From: Carl Moore [REDACTED]
Sent: 04 November 2021 07:57
To: Richard Sherman <Richard.Sherman@arun.gov.uk>
Subject: RE: FG/152/21/HH - 1 Upper West Drive, Ferring

To: Carl Moore [REDACTED]
Subject: FG/152/21/HH - 1 Upper West Drive, Ferring

EXISTING WEST ELEVATION 1:100

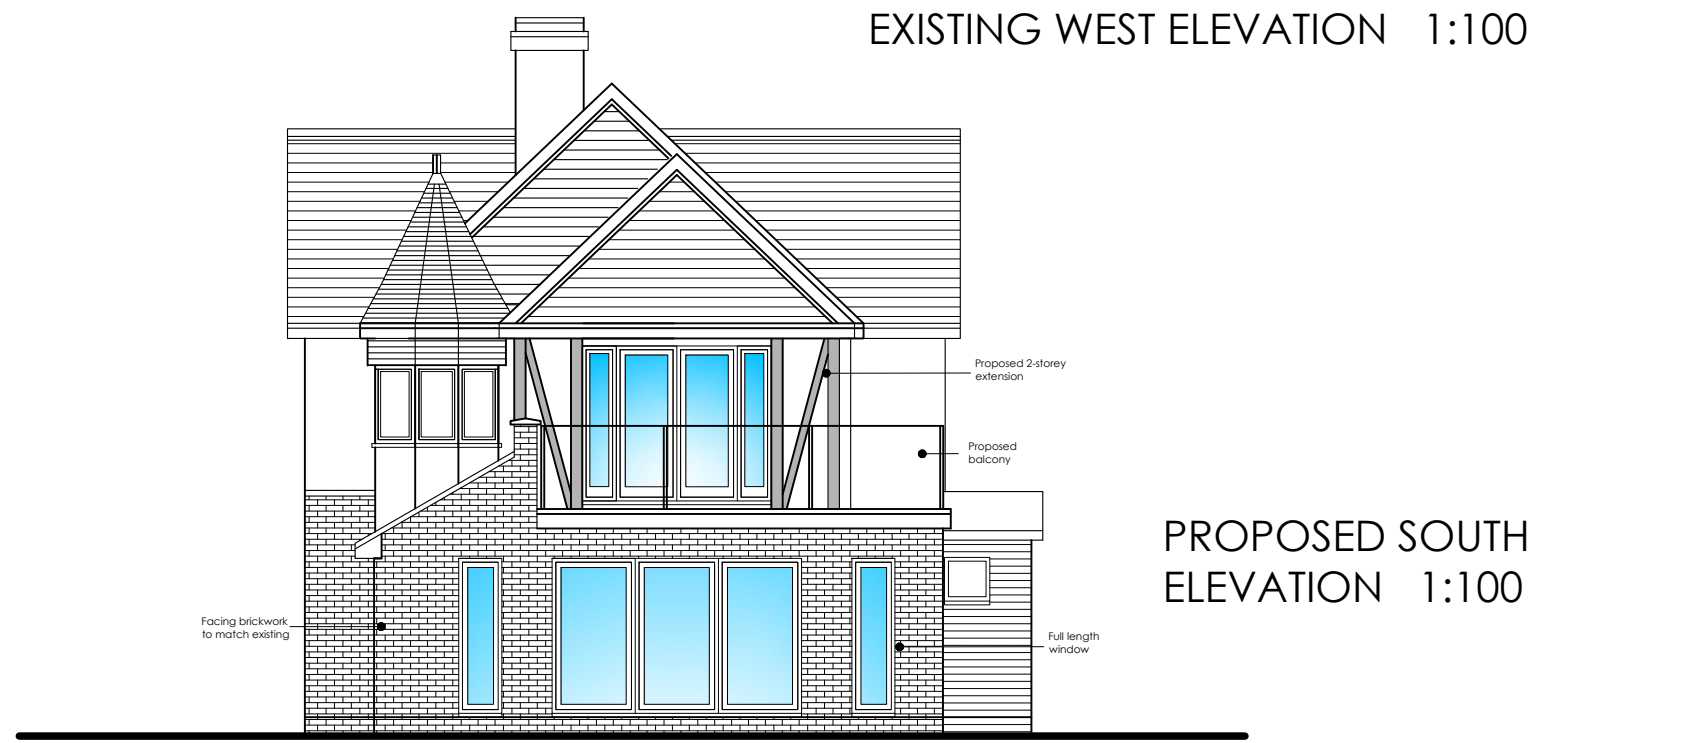
1. We need you to please submit a new 'Proposed Elevations' plan as the current 'Proposed Elevations' has the proposed west elevation labelled as Existing West Elevation so this needs to be clarified that it is the proposed west elevation?
2. Also on the new plan please can you show the height measurements of the proposed new parapet wall to the west elevation balcony please? As we need to know how tall this is in order to work out how much obscured glazing is needed in order to reduce overlooking effects to neighbouring property to west. Therefore otherwise please can you submit a new plan with a obscured glazing screen to a height of 1.7m to the west balcony elevation in order for it to comply? If you don't know the exact specifications or your client doesn't know then we can condition this aspect.

Please find attached the revised plan as requested. I have included the 1.7m obscure screen on the elevations and first floor plan. I should also be grateful if you could include this within the planning conditions.
